Submissions Received after the Close of the Examination

TR010043

Great Yarmouth Third River Crossing

APPLICATION BY NORFOLK COUNTY COUNCIL FOR AN ORDER GRANTING DEVELOPMENT CONSENT FOR THE GREAT YARMOUTH THIRD RIVER CROSSING PROJECT. RULE 17. REQUEST FOR FURTHER INFORMATION, DEADLINE 8.

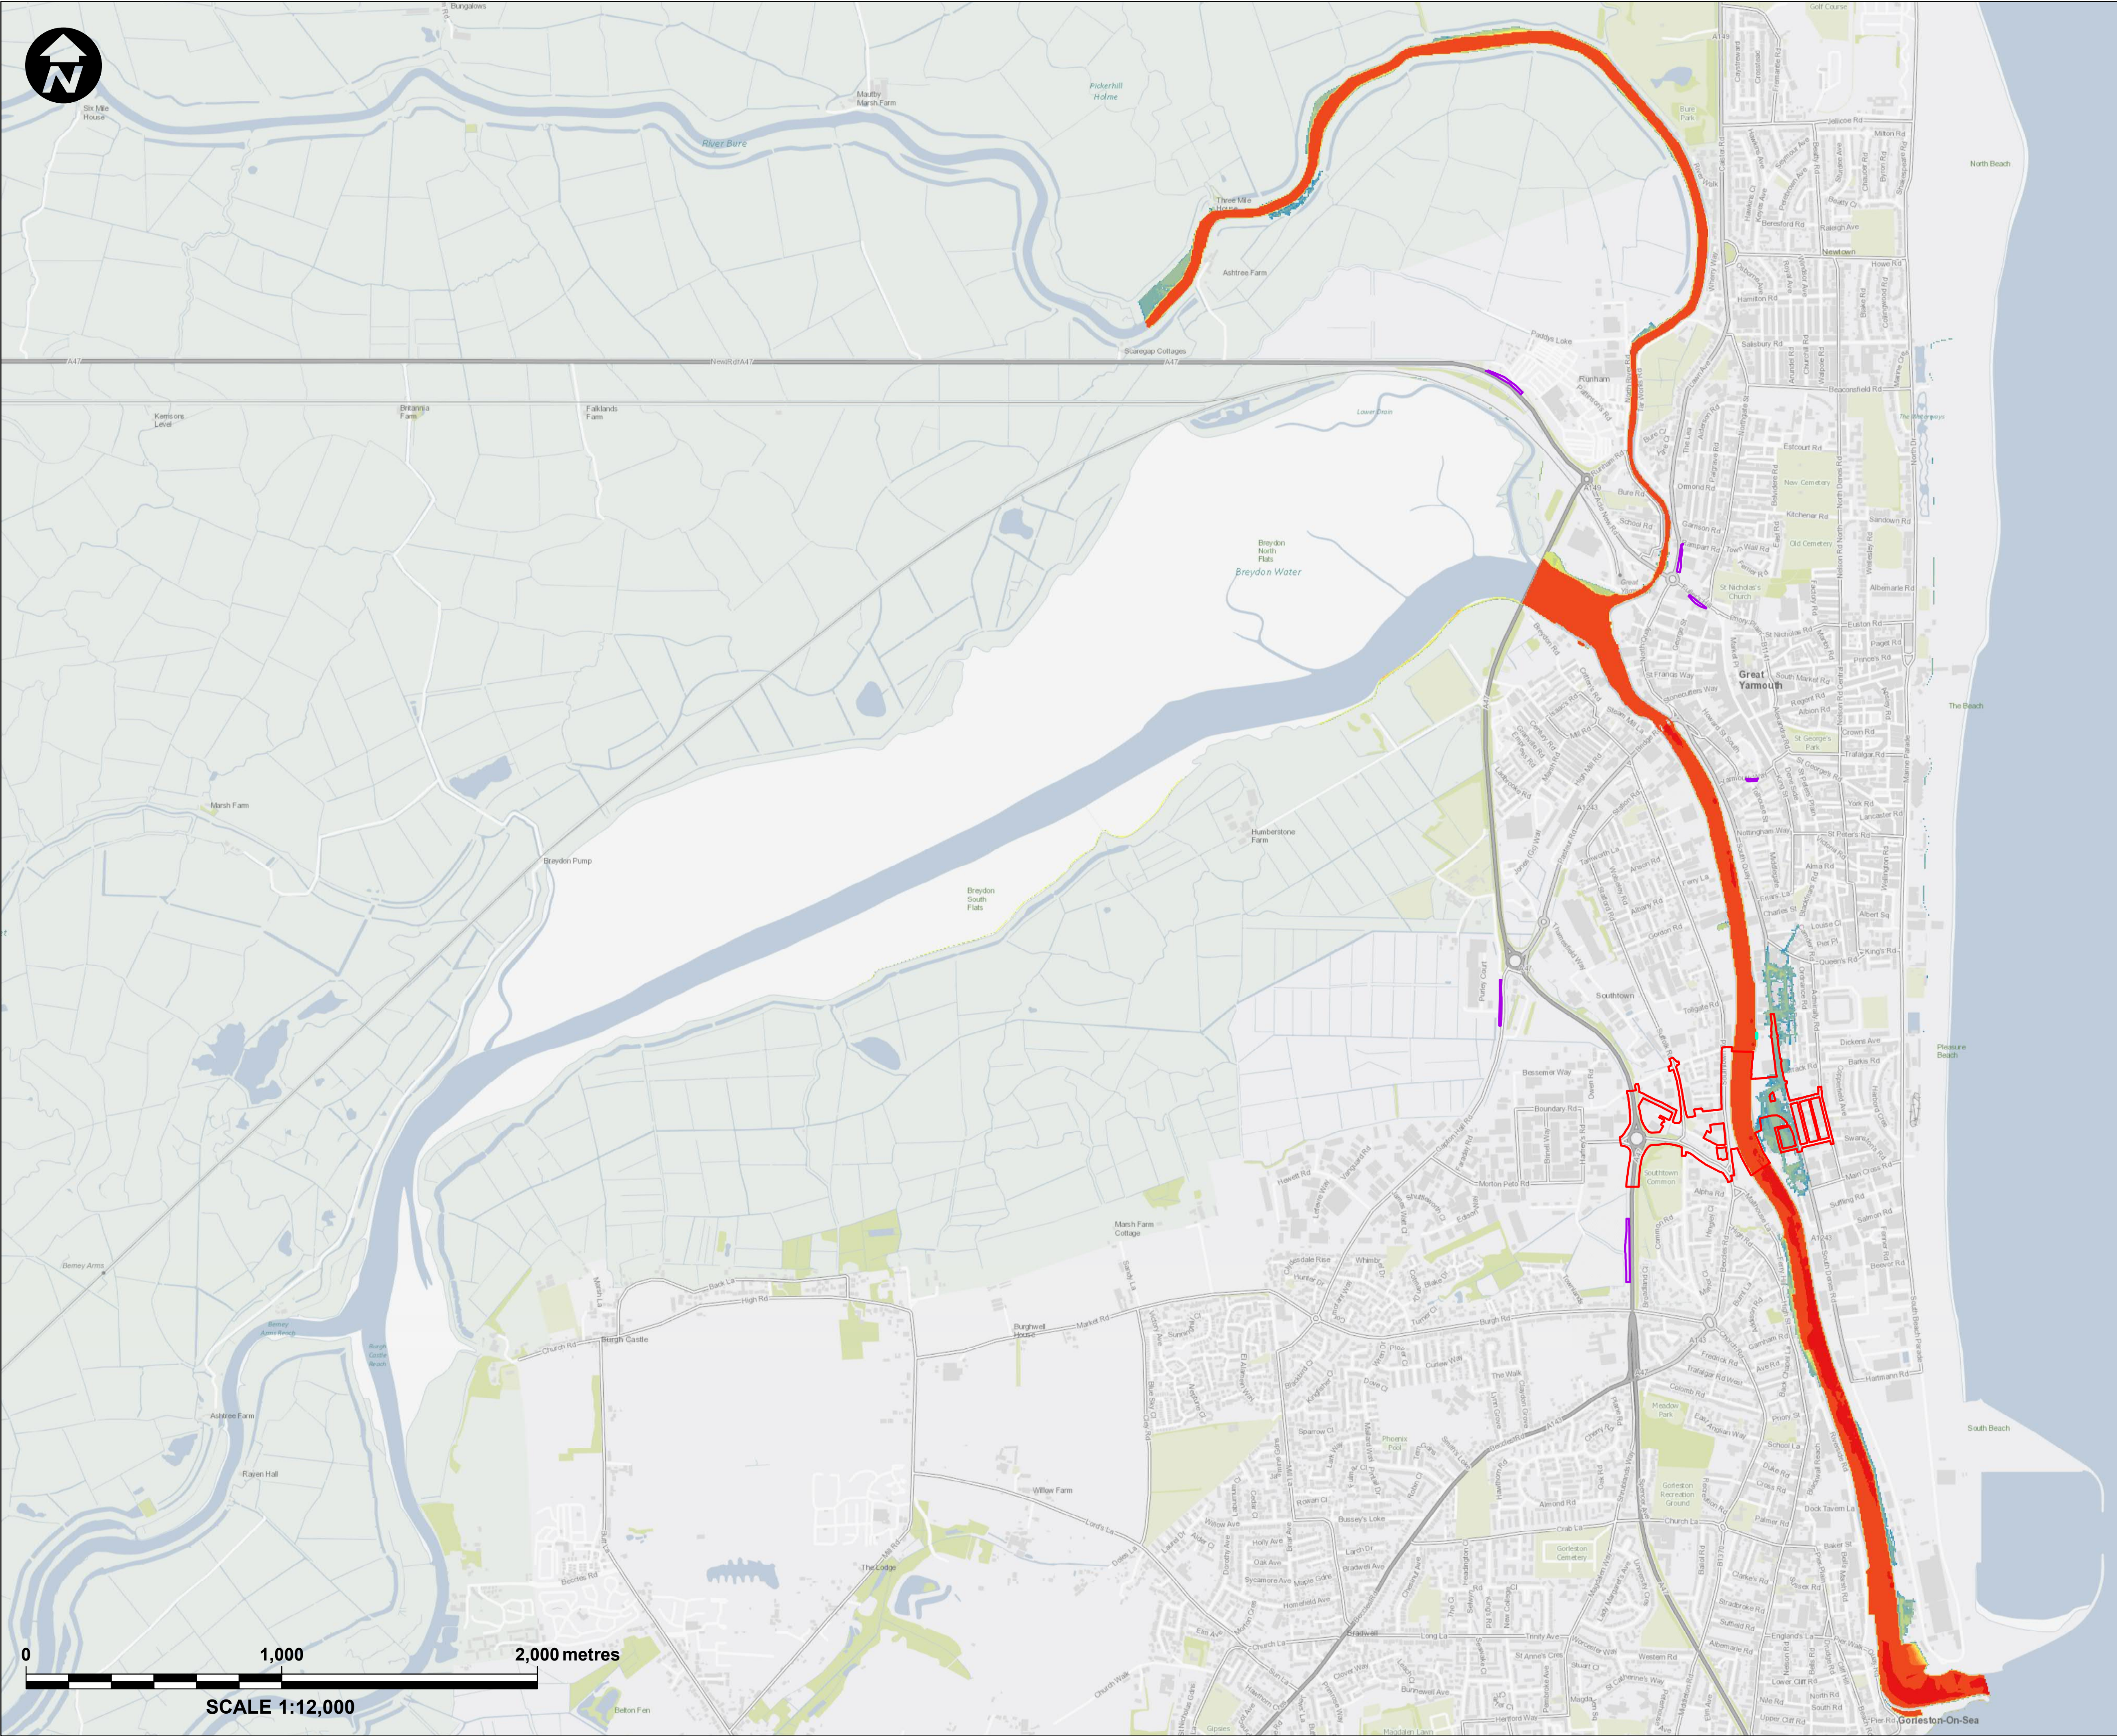
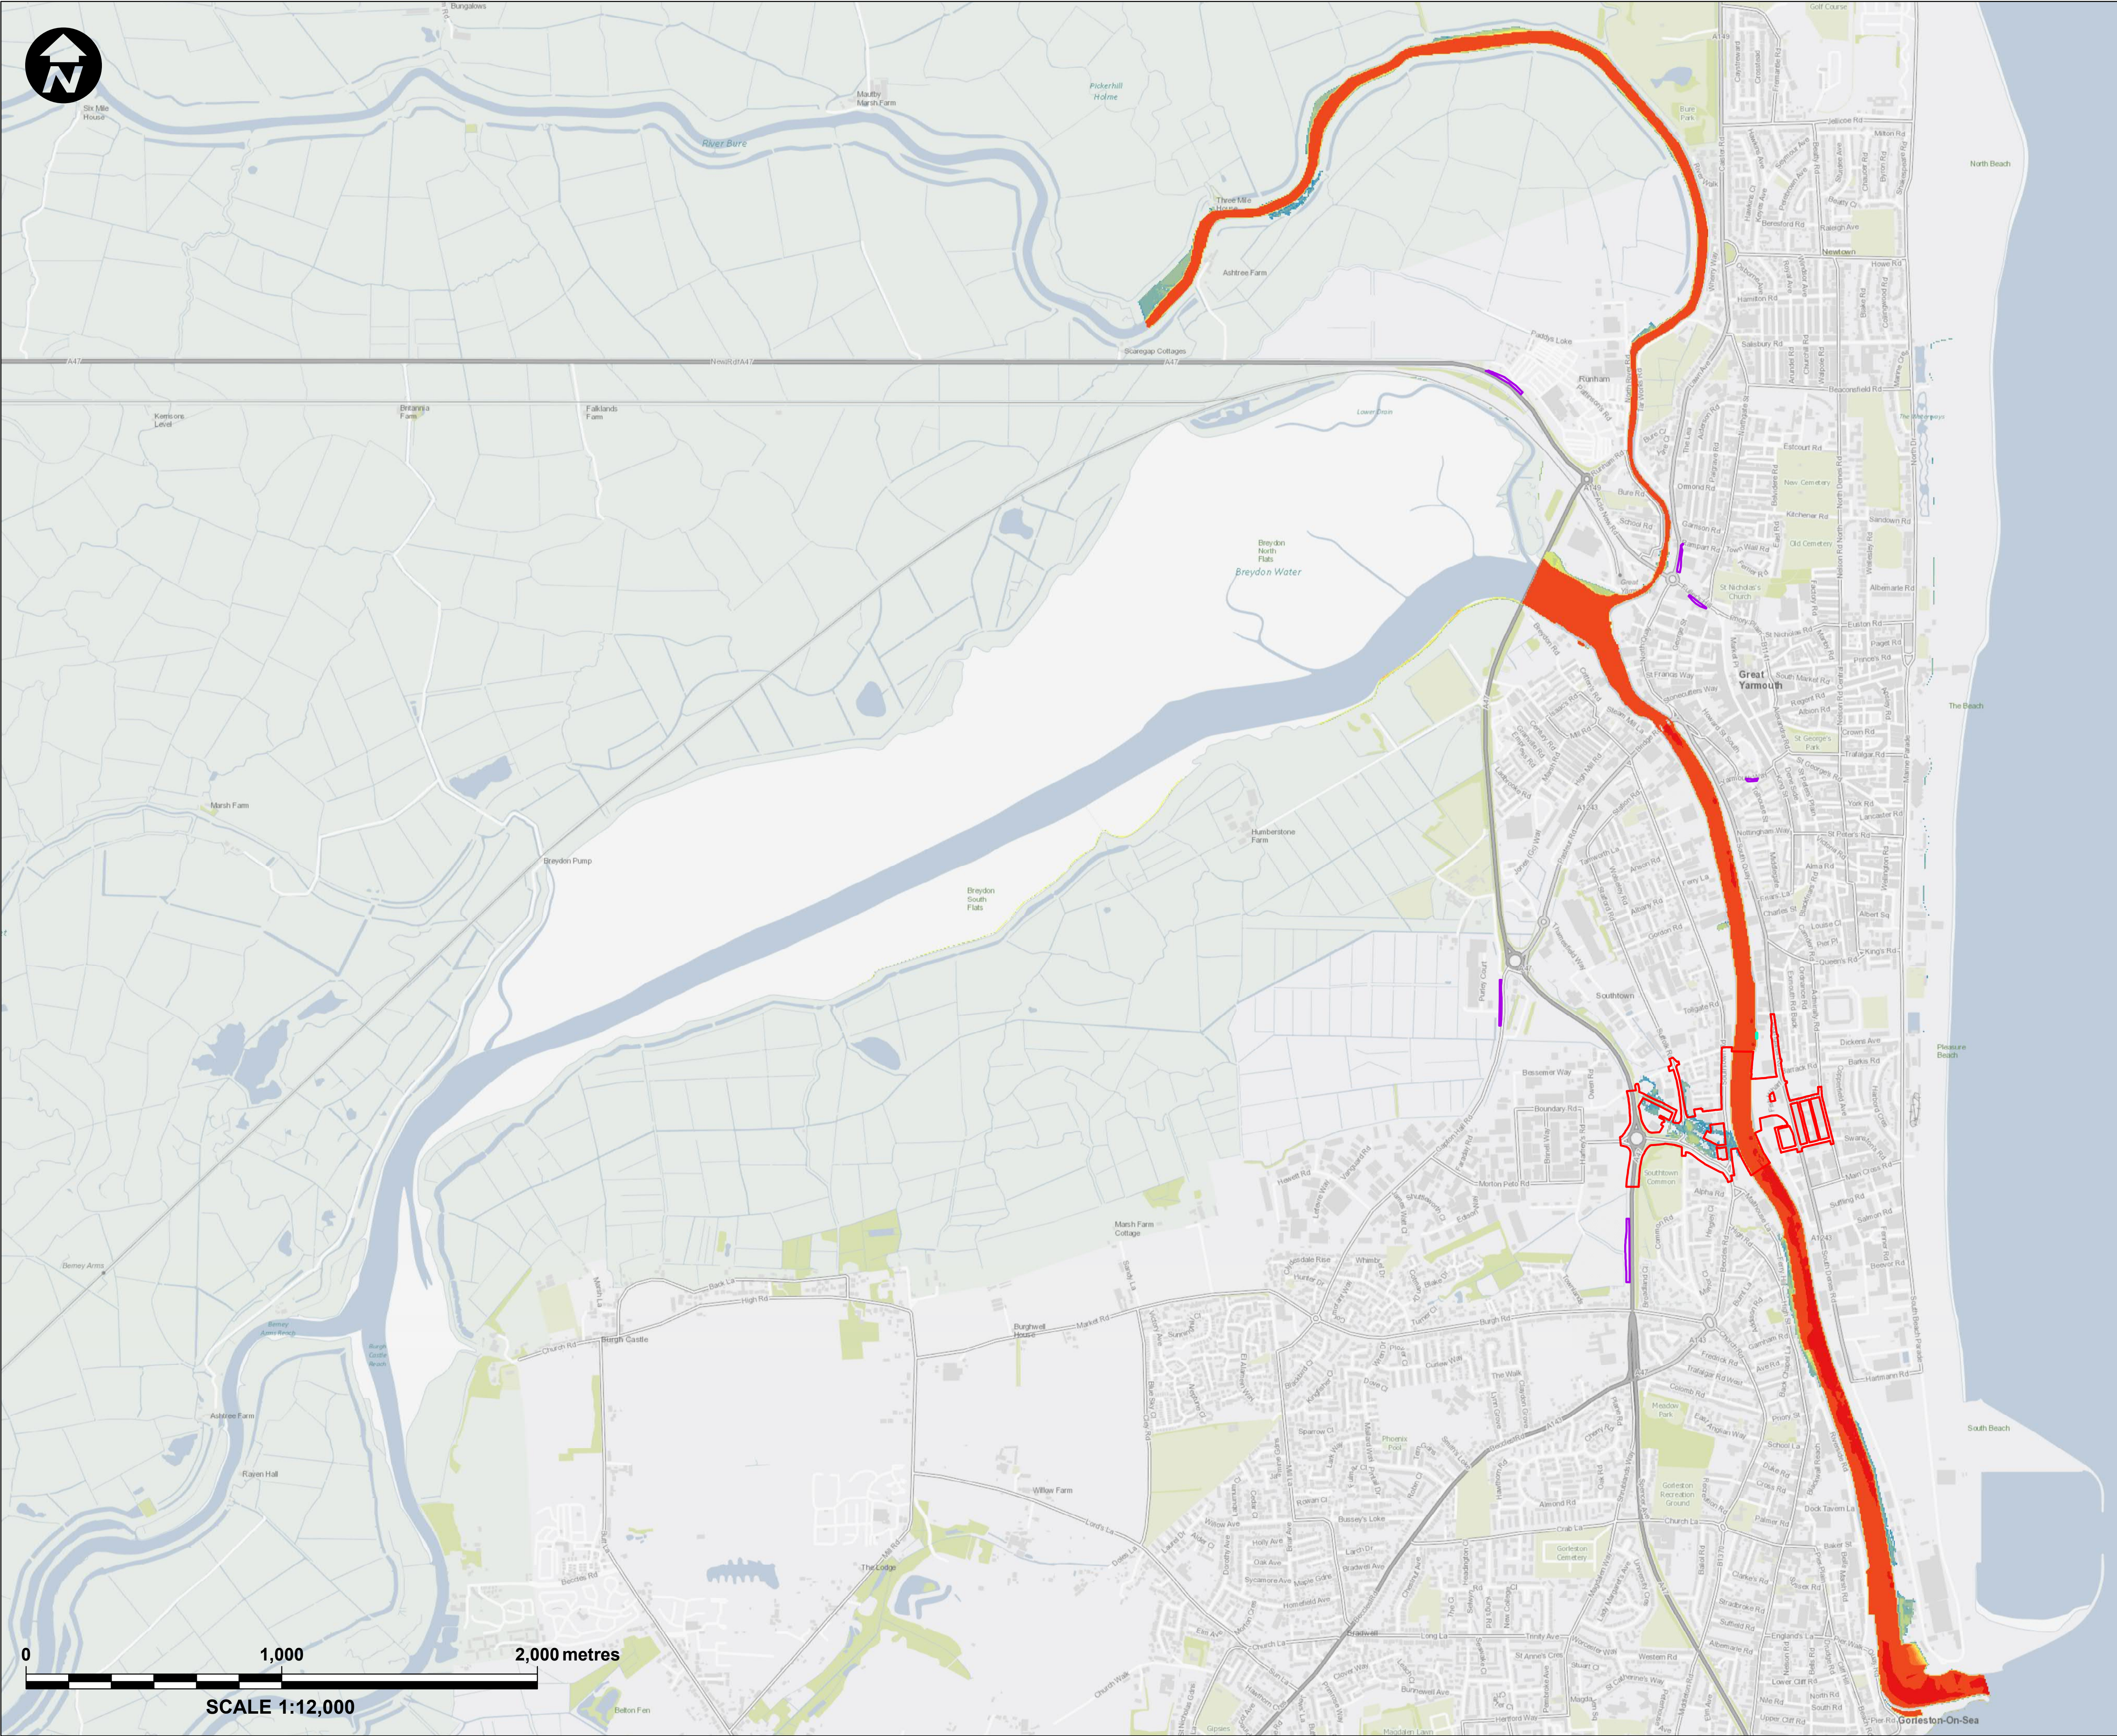
We consider that although the submitted data does not present the fullest picture of the impacts of the proposed development on third parties, and specifically residential properties; it does provide the Examining Authority with sufficient information to make a judgement on flood depths, flood velocities and flood hazard in the areas of additional flood extent in the event of a breach occurring.

We consider that best practice is to provide figures/maps showing the difference in flood depths over the whole flood extent with the bridge infrastructure in situ and not only the superimposed differences on the current day baseline flood extents. The existing figures show the depth of flooding in the event of a breach scenario and are shown alongside the baseline of no bridge we feel that the existing depth difference figures do not show the change in flood depth in additional areas of flood extent that occur as a consequence of the bridge structure being in situ (these areas would previously have been dry). We do, however, note that the ExA may view the flood depth information for those additional inundated areas by looking at the individual flood depth maps.

Additional information in respect of the tidal residual breach analysis was supplied by the Applicant on 19 March 2020. Following review I am able to confirm that the information satisfies Environment Agency concerns; as such our objection to the DCO is withdrawn.
